Application for a non-material amendment following a grant of planning permission.

<input type="text" value="Conversion of barn to holiday let."/>	
Reference number:	<input type="text" value="18/02168/FUL"/>
Date of decision	<input type="text" value="01/02/2019"/>

Project: **PRIORY FARM NISSEN HUT SUFFOLK**
 Drawing: **SHORT ELEVATIONS OPTION 1**

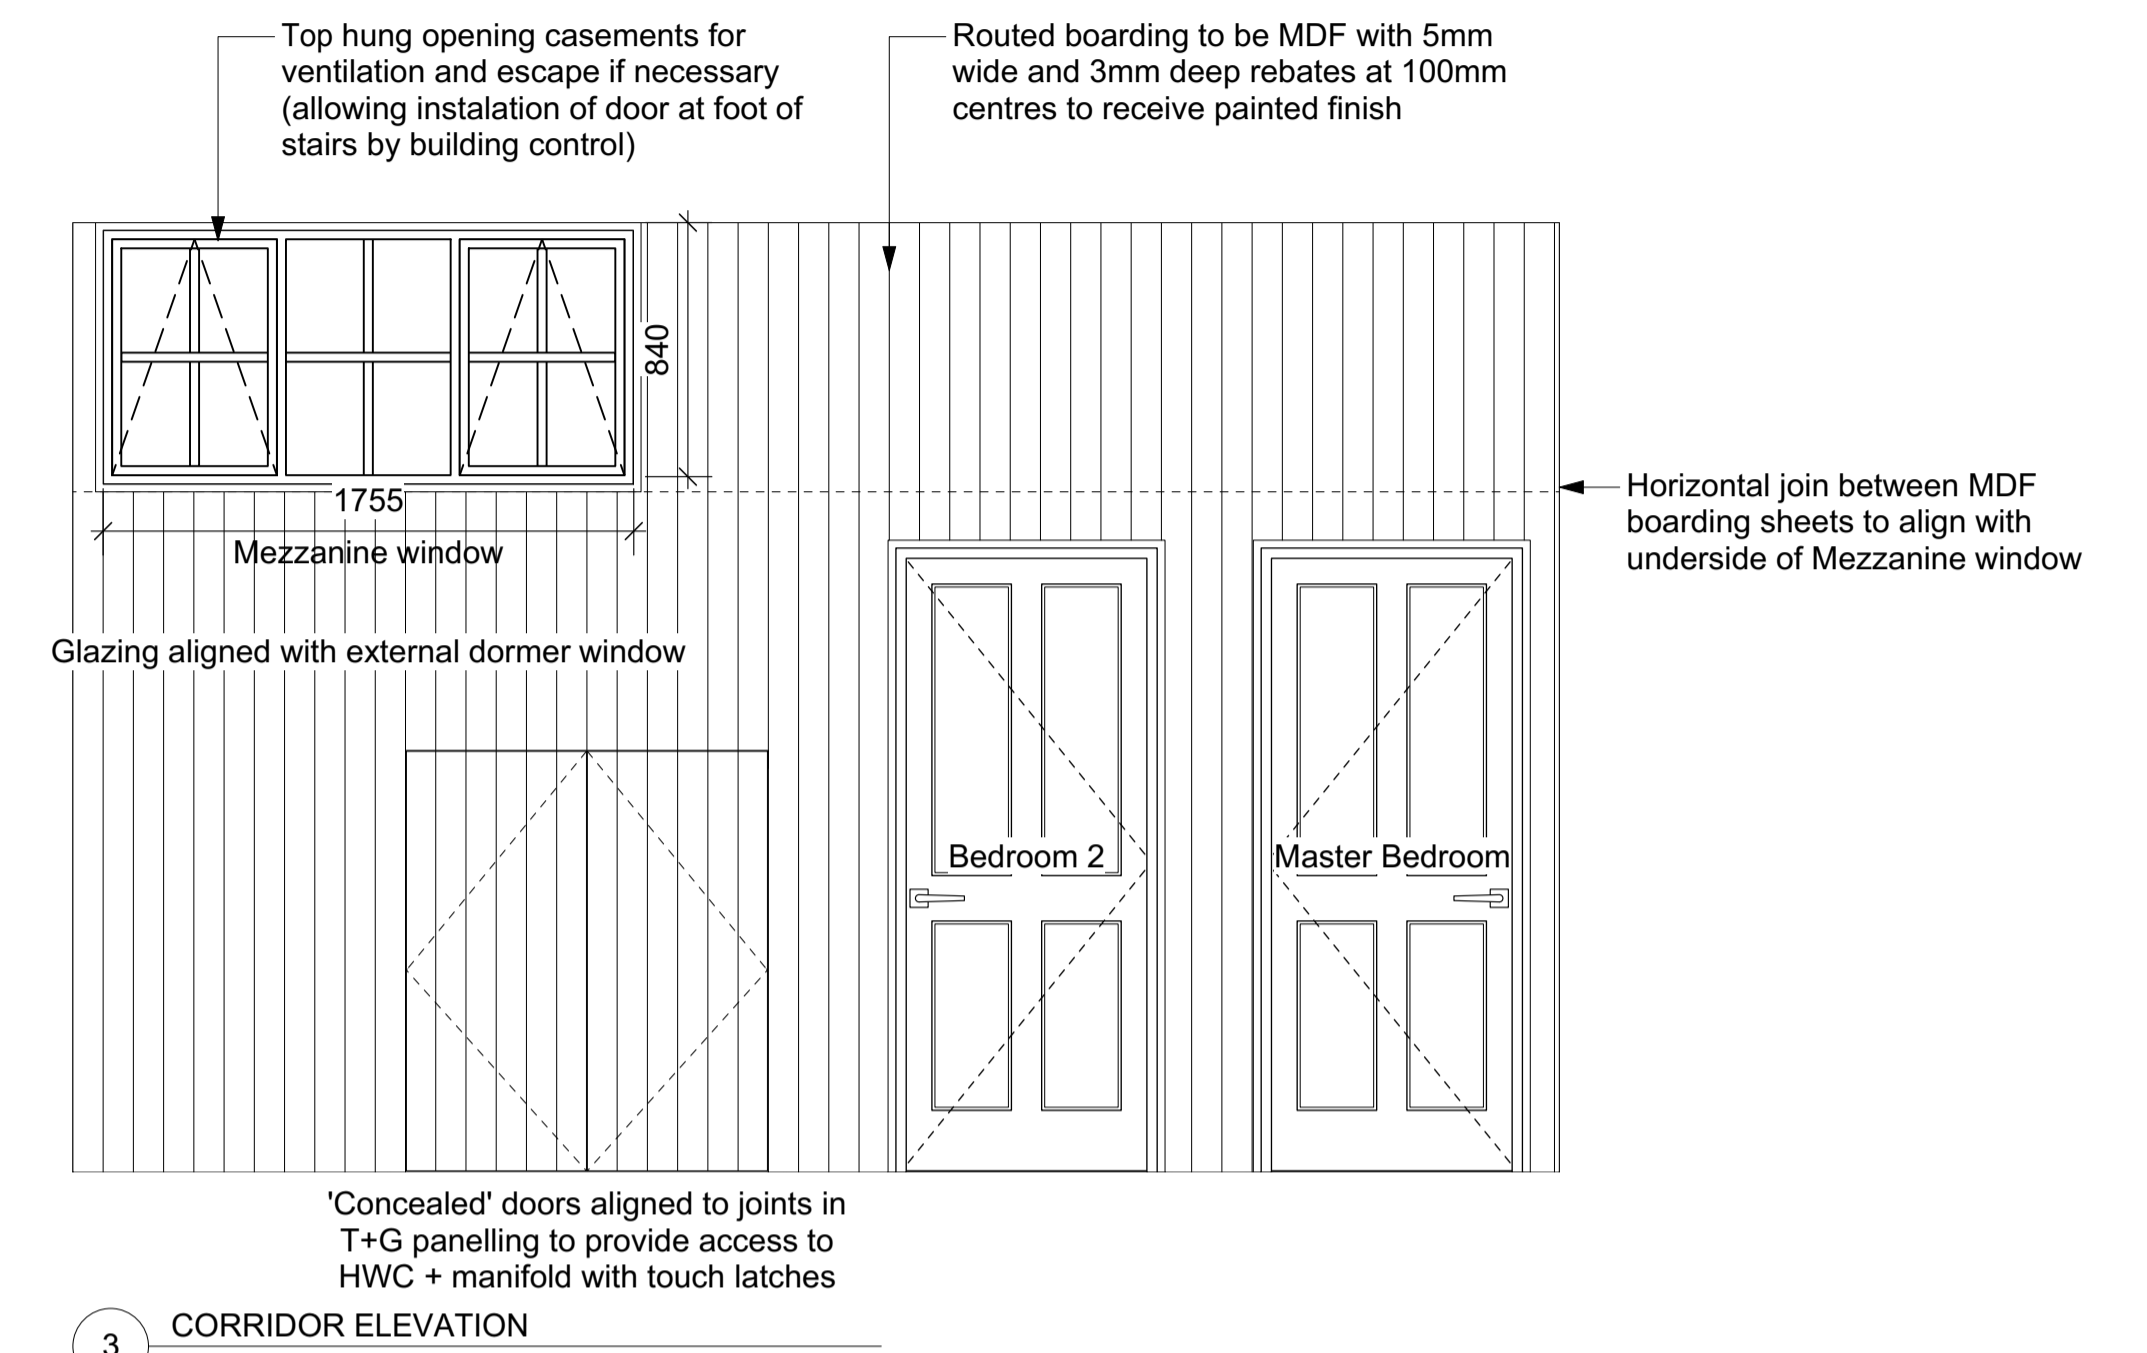
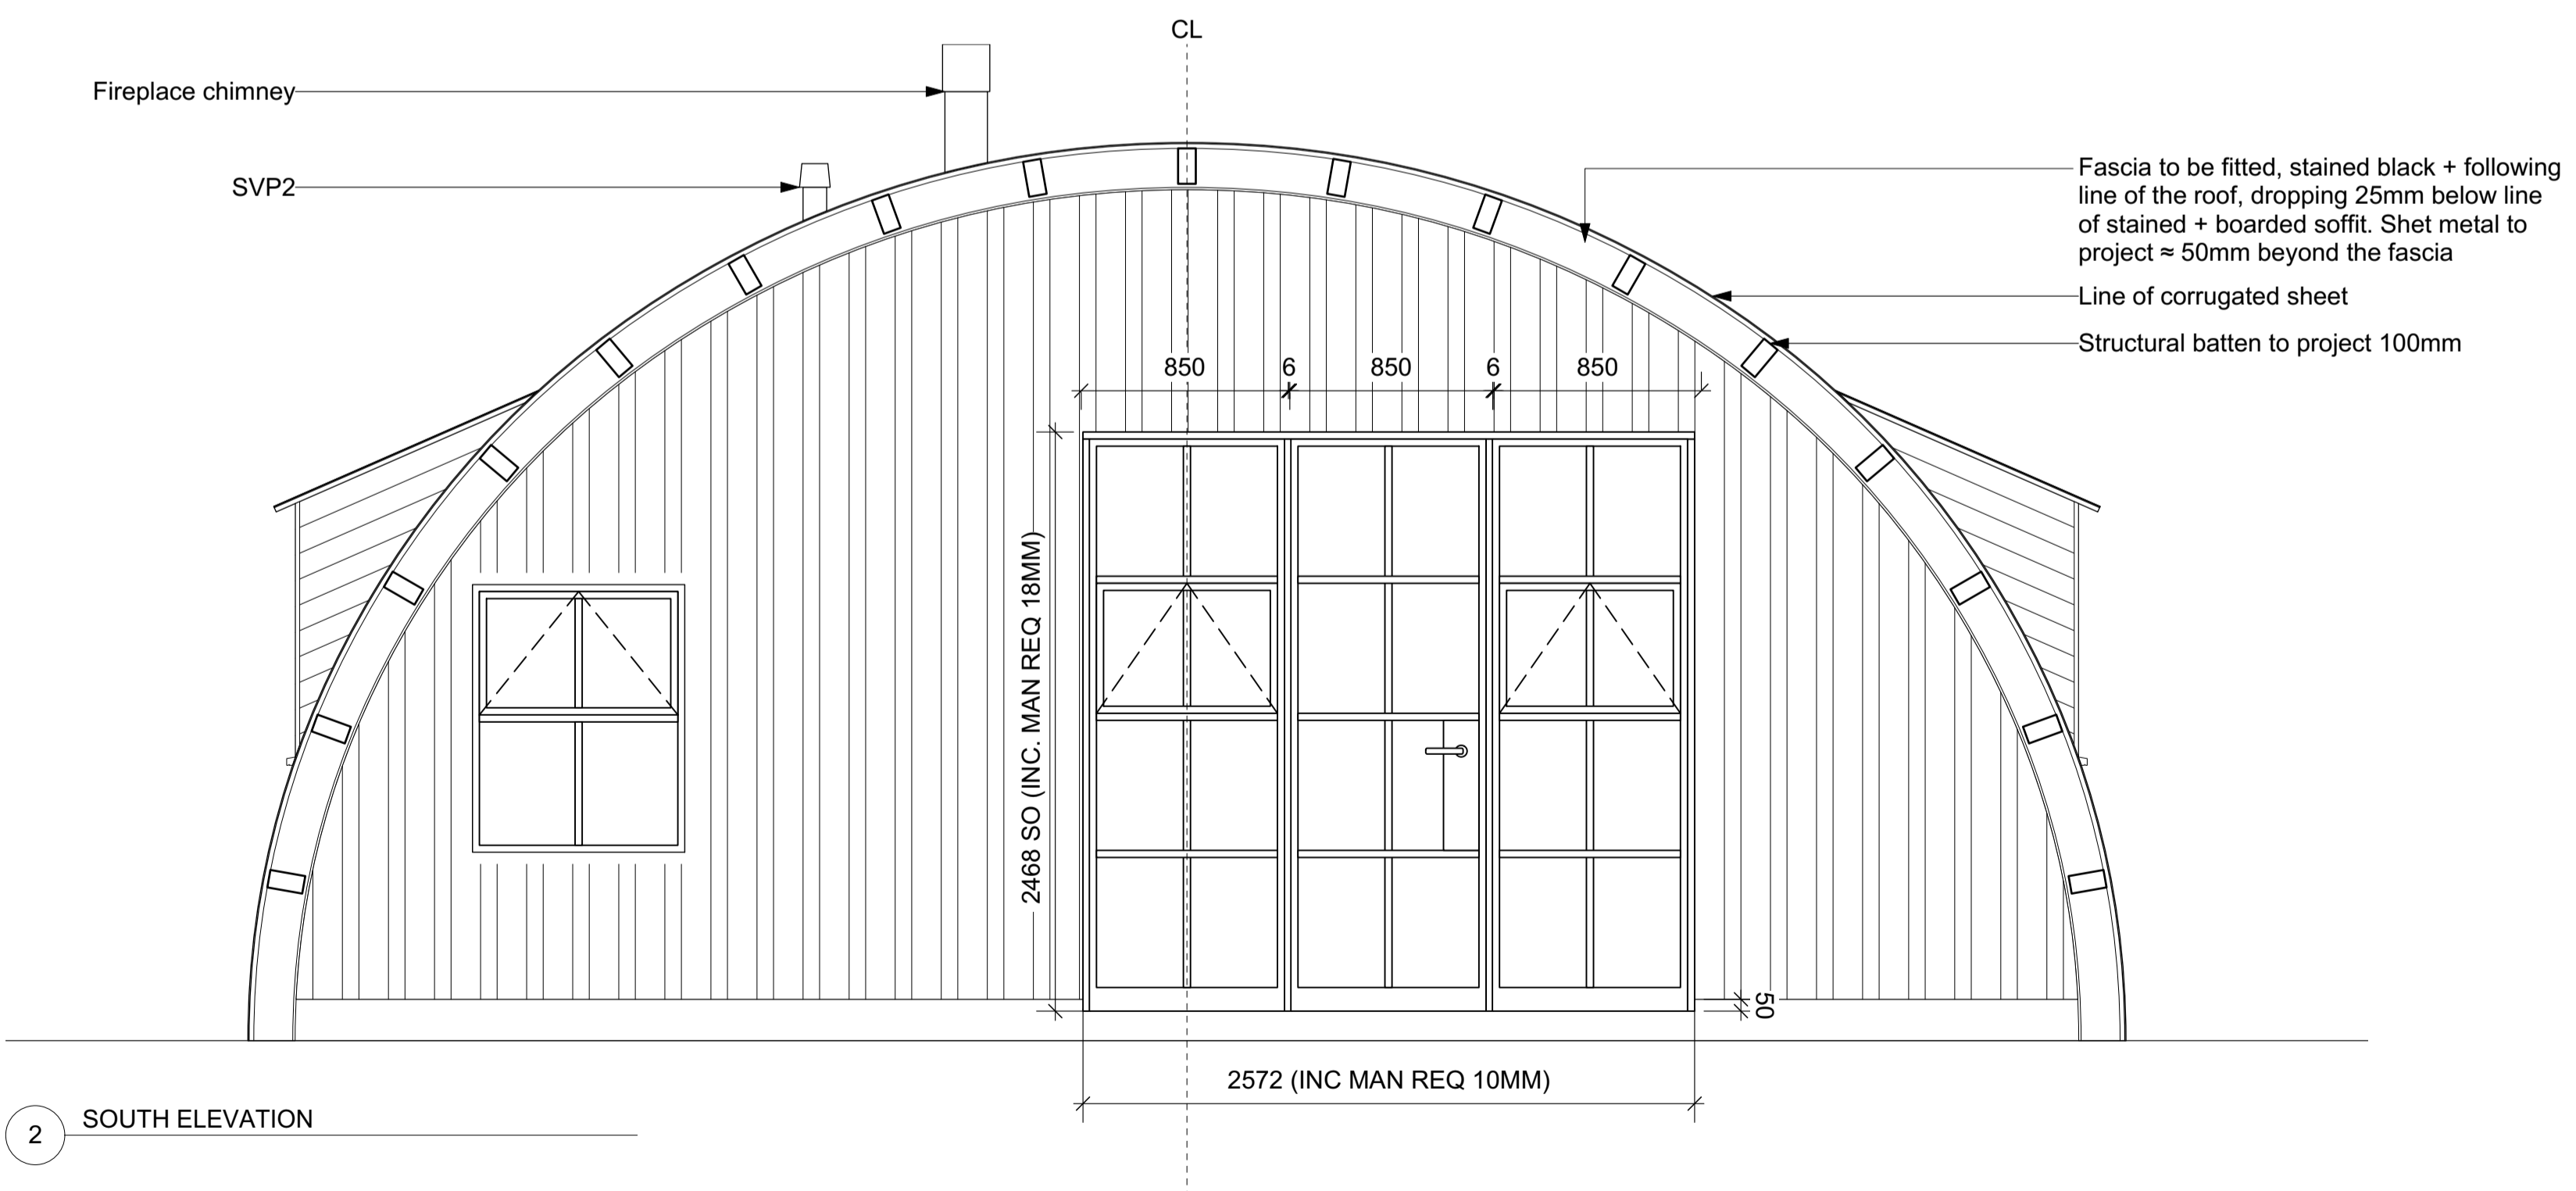
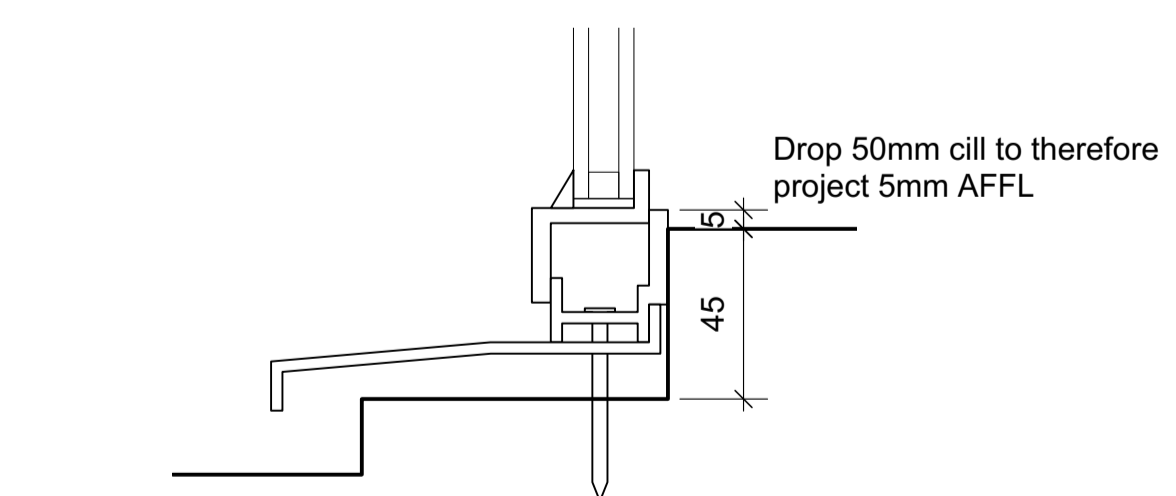
On the west elevation there are now only two dormer windows where originally there were to be three. This is to match a new internal layout. On the north and south gable elevations there is now high-spec Crittal Glazing in a new, similar scale, arrangement that is updated from the original application. Crittal Glazing is used throughout the new design. Also, on the north and south gable elevations there is now a 360mm overhang of the roof to provide some cover to doorways.

The design was updated to provide a more useable internal layout, making better use of the Nissen Huts unusual form, with higher quality finishes and glazing. These design choices resulted in updated external window layouts which better serve the interior. The roof overhang has been added to help protect the two entrances and this new glazing.
